Ref: **Planning Applications: AW/40/12**  
25 Kingsway, Craigweil House Conservation Area

sheet 2 of 2

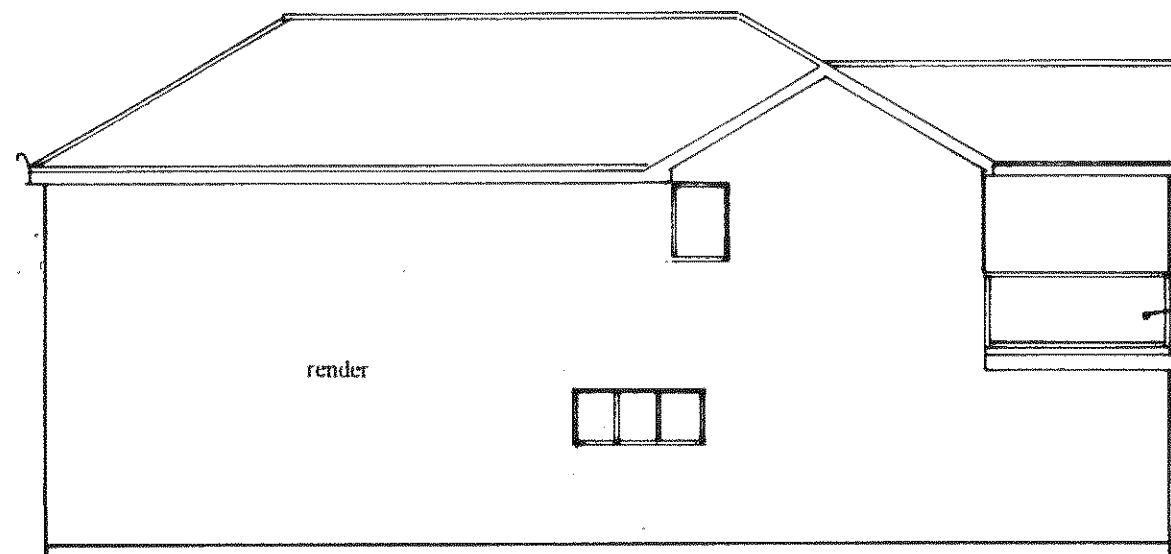
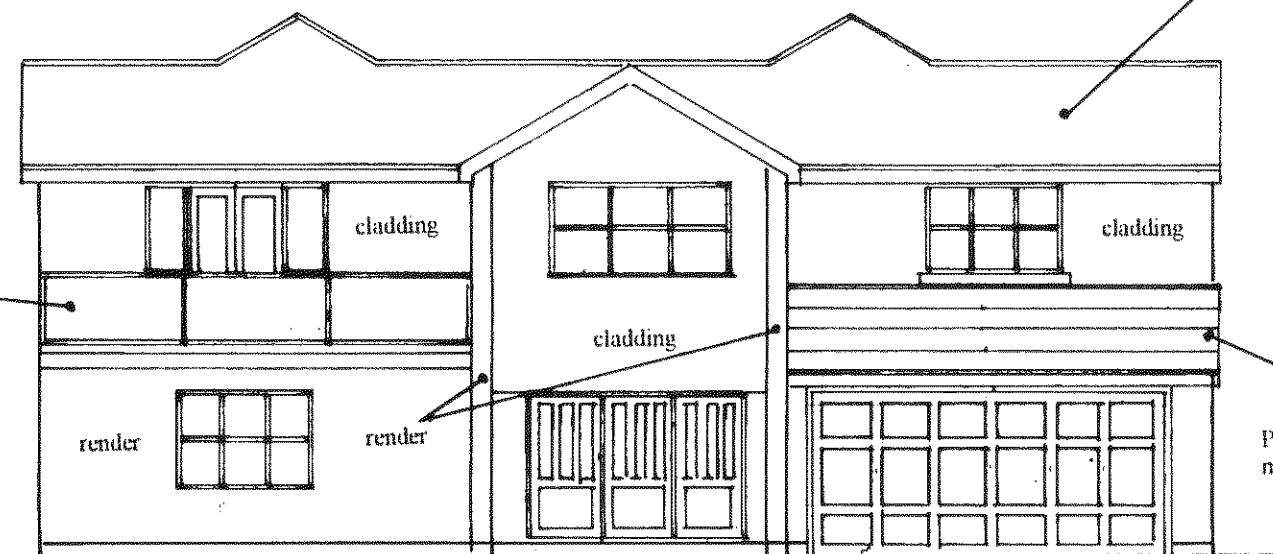
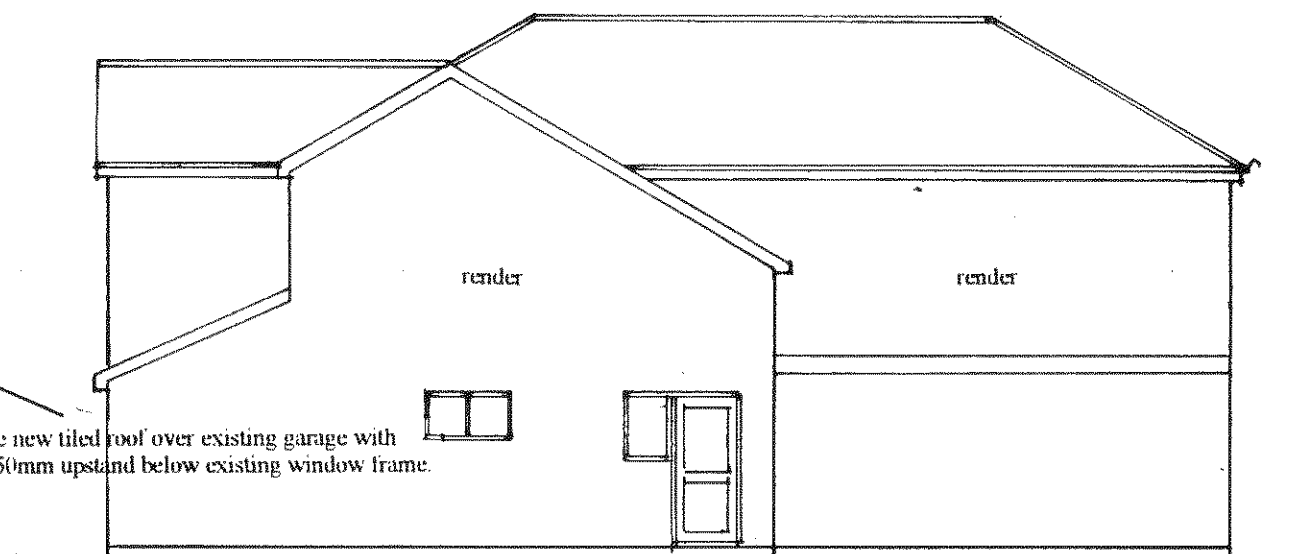
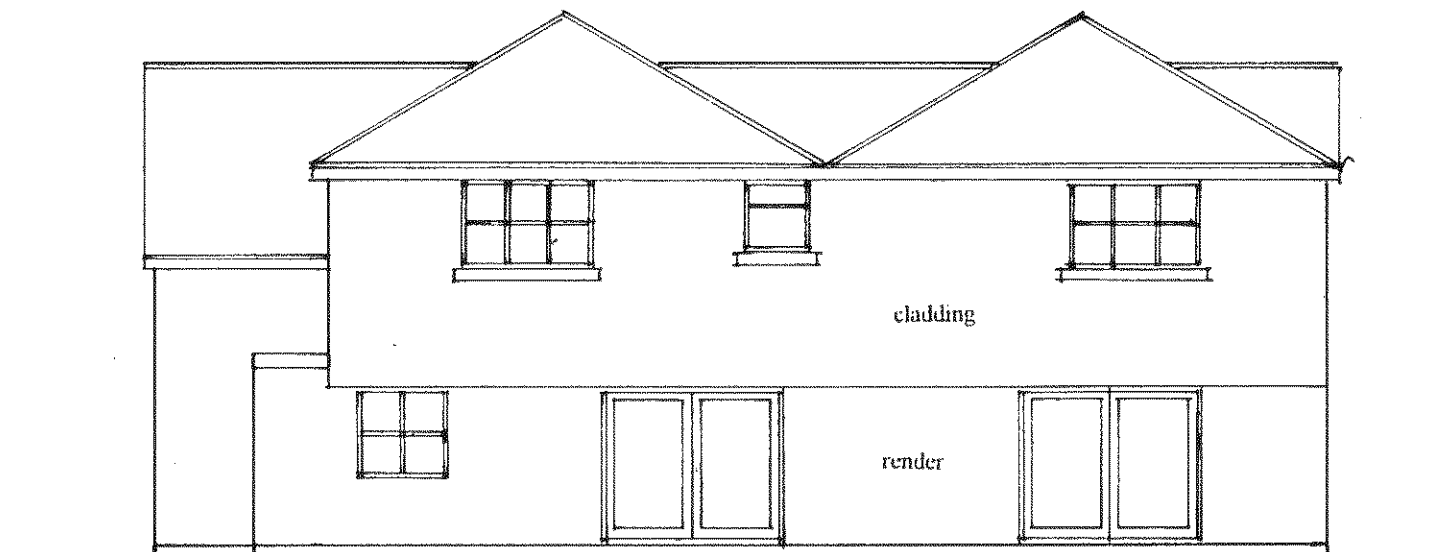
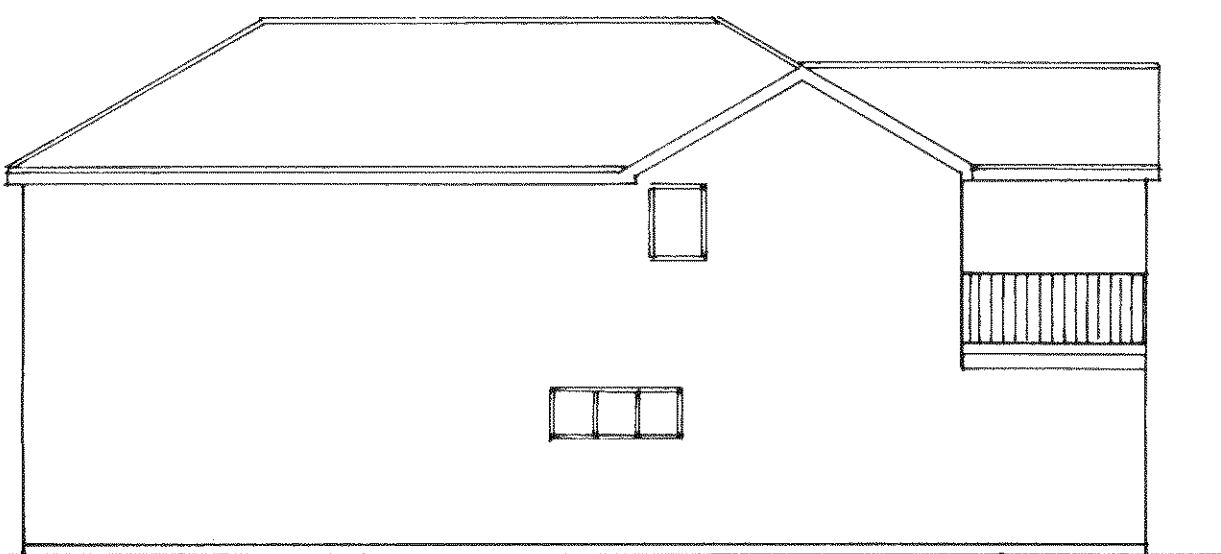
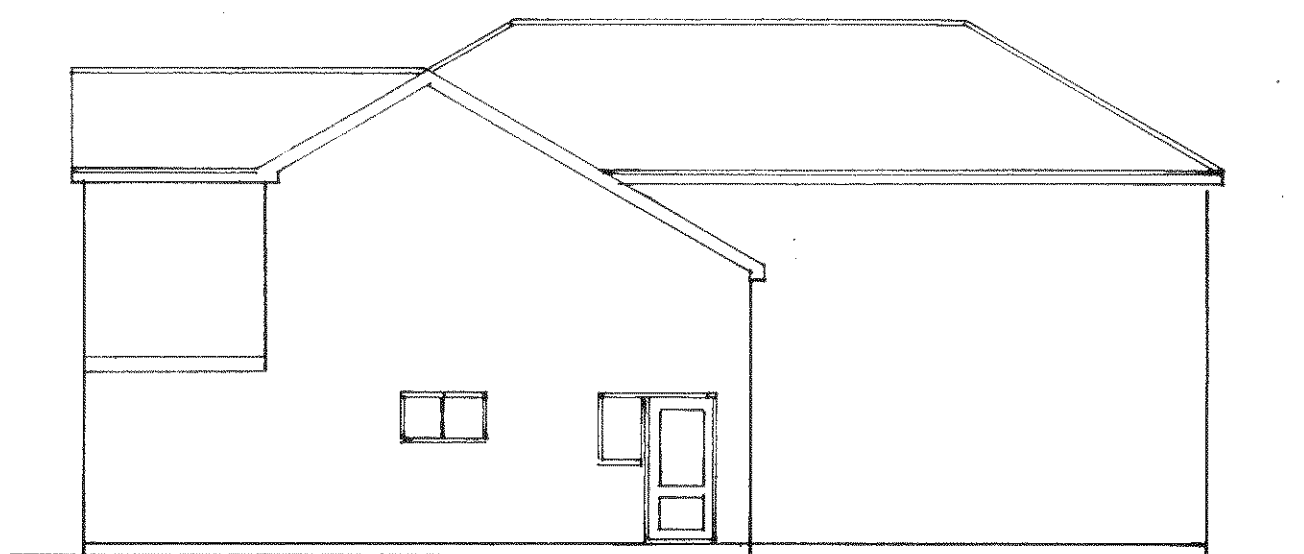
To change from the red/brown coloured brickwork to the 'cream' selected will completely change the appearance of this house, out of character with what exists and with its neighbours. More importantly, the proposals cannot surely Preserve or Enhance the Character of the Conservation Area. This too, for **ALL ELEVATIONS**, North, South, East and West.
